**RE: MAJOR PROJECT 08_0014 – 63 LOT RESIDENTIAL SUBDIVISION, MORISSET PARK –
REQUEST TO AMEND CONDITION B9 ROAD DESIGN**

1. INTRODUCTION AND PROPOSED AMENDMENT

Figure 2: Location of the Intersections Affected by MP08_0014 MOD 1

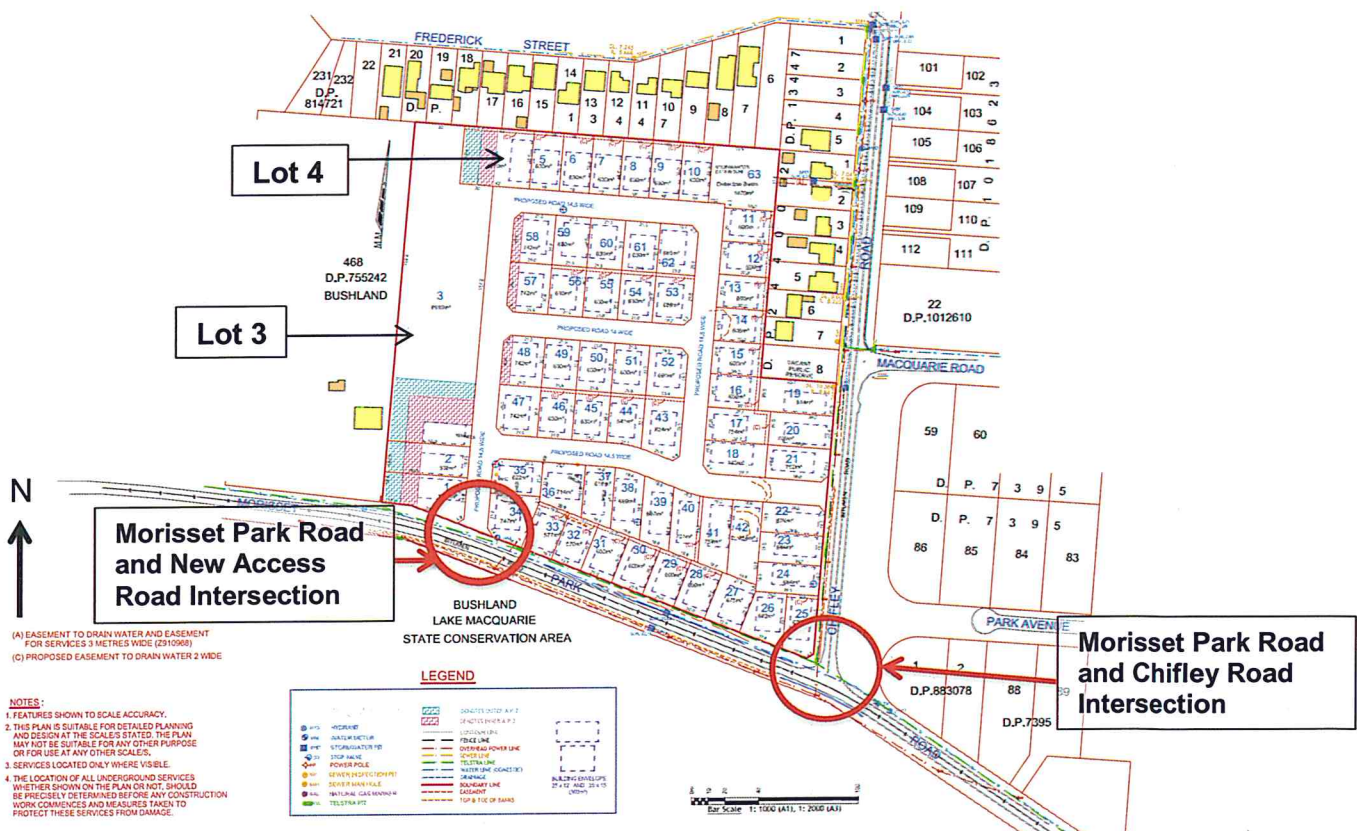
If the existing volumes shown in the 2009 TPK report and the expected impact of this development are taken into consideration, the implied intersection improvements for Morisset Park Road and the new access road remains at BAR based on the 2010 Austroads reference (i.e today's standards).

We acknowledge pursuant to Figure 4.9 the implied intersection improvements required for the Chifley Road intersection is CHRS. Notwithstanding this, TPK in their traffic analysis attributed the impact of the subject development on the Chifley intersection to be valued at 20% of the total intersection upgrade. Increase in right turns into Chifley Road as a result of the development will be minimal. Furthermore, TPK in their traffic analysis stated, *'of the total developments identified in reports referenced by TPK for this review the subject development represents around 1% of the total increase in traffic demand on the road network.'*

We are of the opinion Morisset Park Road can accommodate a BAR in both locations being the Morisset Park Road and new access intersection and Morisset Park Road and Chifley Road intersection without major disruption to the existing road layout and environment. Furthermore, the BAR rural treatments are considered applicable as the frontage for these works are along the Lake Macquarie State Conservation area where the necessity for kerb and gutter will not arise.

Figure 3: AUR (Approved) and BAR (Proposed) Treatment

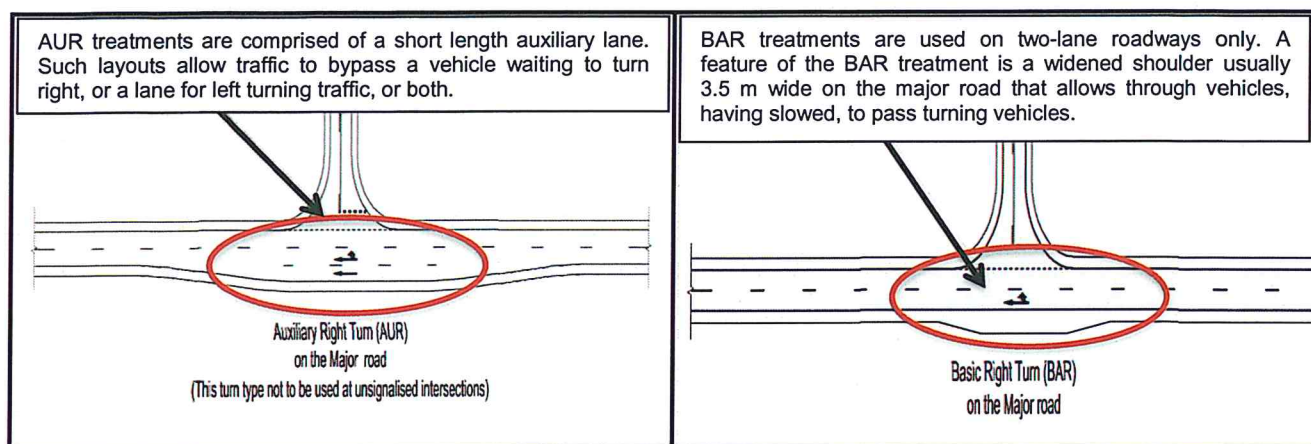
The applicant wishes to amend b and c above from an AUR geometric intersection to a BAR (Basic Intersection Layout). In particular the following wording is proposed for b and c.

- b. A BAR intersection shall be constructed for Morisset Park Road and Chifley Road;*

- c. A BAR intersection shall be constructed for Morisset Park Road and the New Access Road to the subdivision, including the provision of bus amenity;
